FC/16/17

From: Lee Martin [REDACTED]
Sent: 12 January 2012 15:00
To: Eve Hearsey
Cc: Philip Satchell
Subject: ASDA Worthing - Additional Proposed Alterations
Attachments: West Boundary Mods.pdf

From: Eve Hearsey [REDACTED]
Sent: 07 December 2011 12:16
To: Christine Tetlow
Cc: Karl Roberts; Nikolas Antoniou
Subject: RE: ASDA Worthing - Additional Proposed Alterations

Proposed Elevations

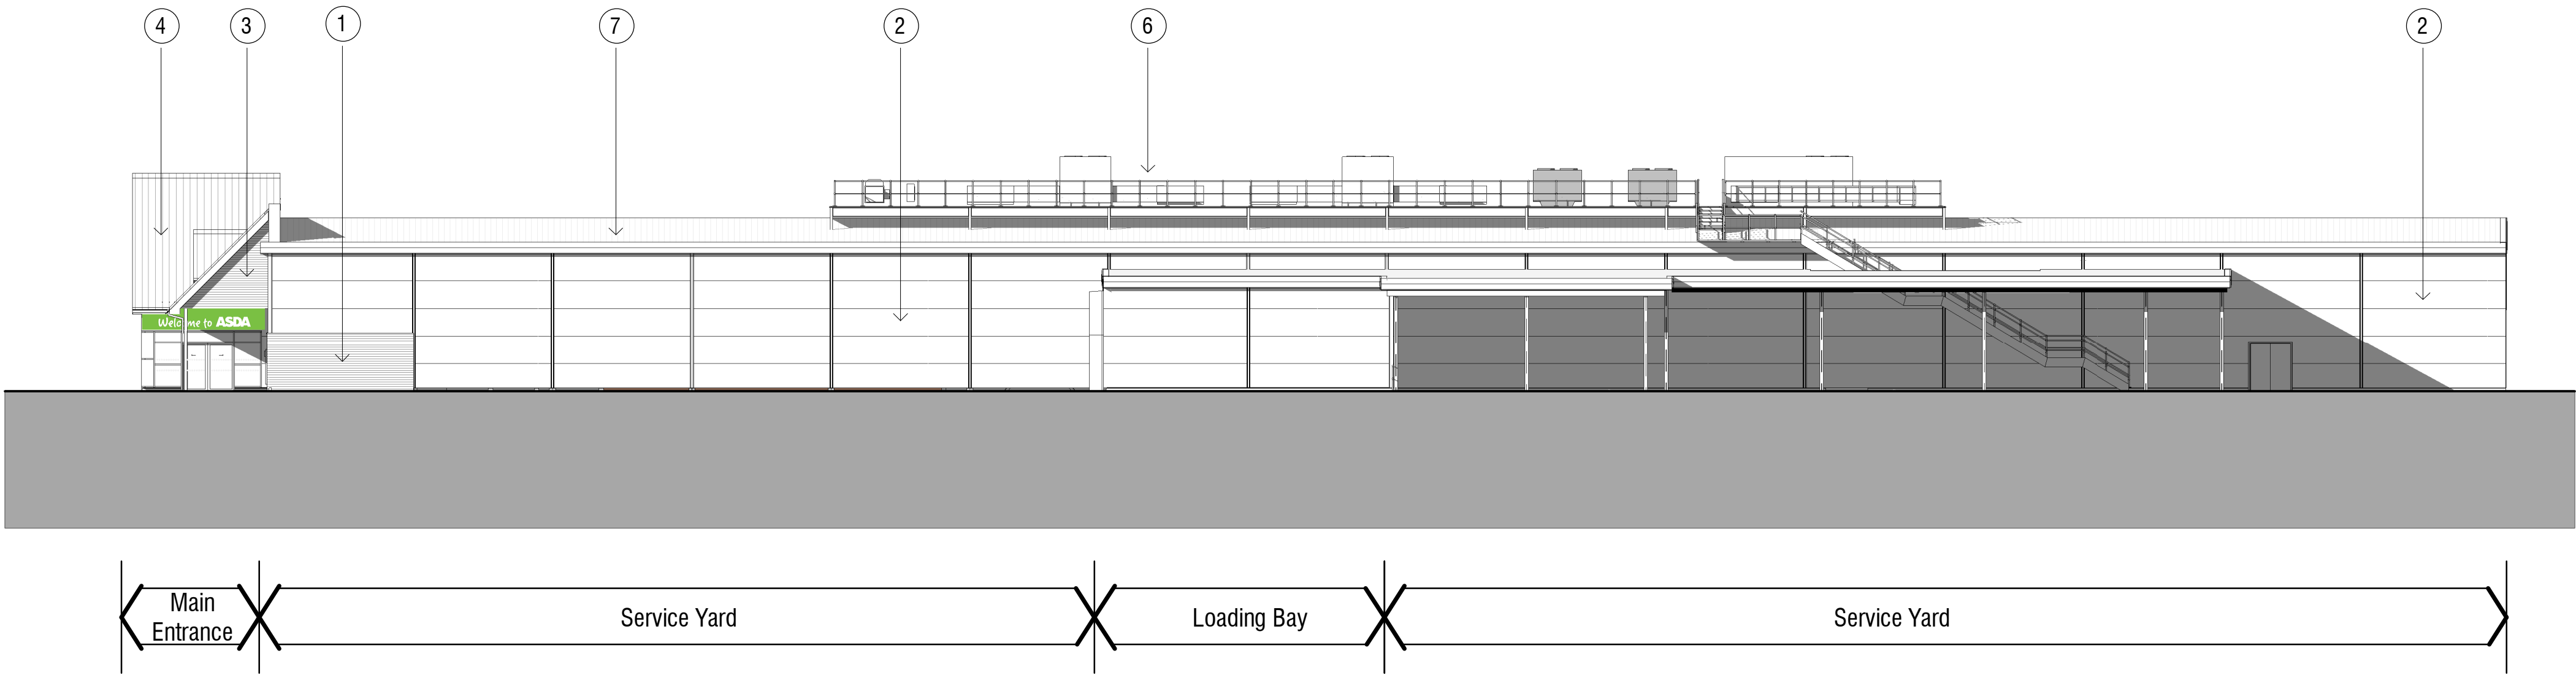
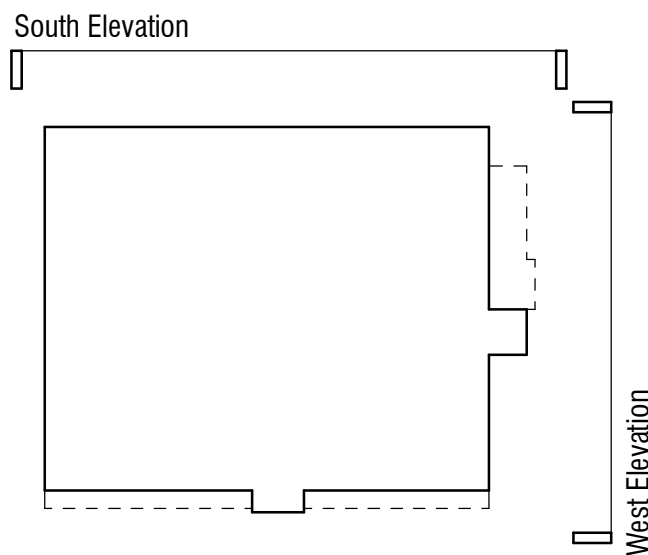
Drawing No. 10.120.A(00)30_04 Revision A Proposed South & West Elevations
Amendments

- A) service yard canopy - NMA;
 - B) access doors relocated to suit internal layout - NMA; and
 - C) loading bay enclosure increased by 6 metres - NMA
- (the service yard canopy and the increase of 6 metres could be argued to be more than a Non Material Amendment, but because of its location I feel that they can be dealt with via the NMA route);
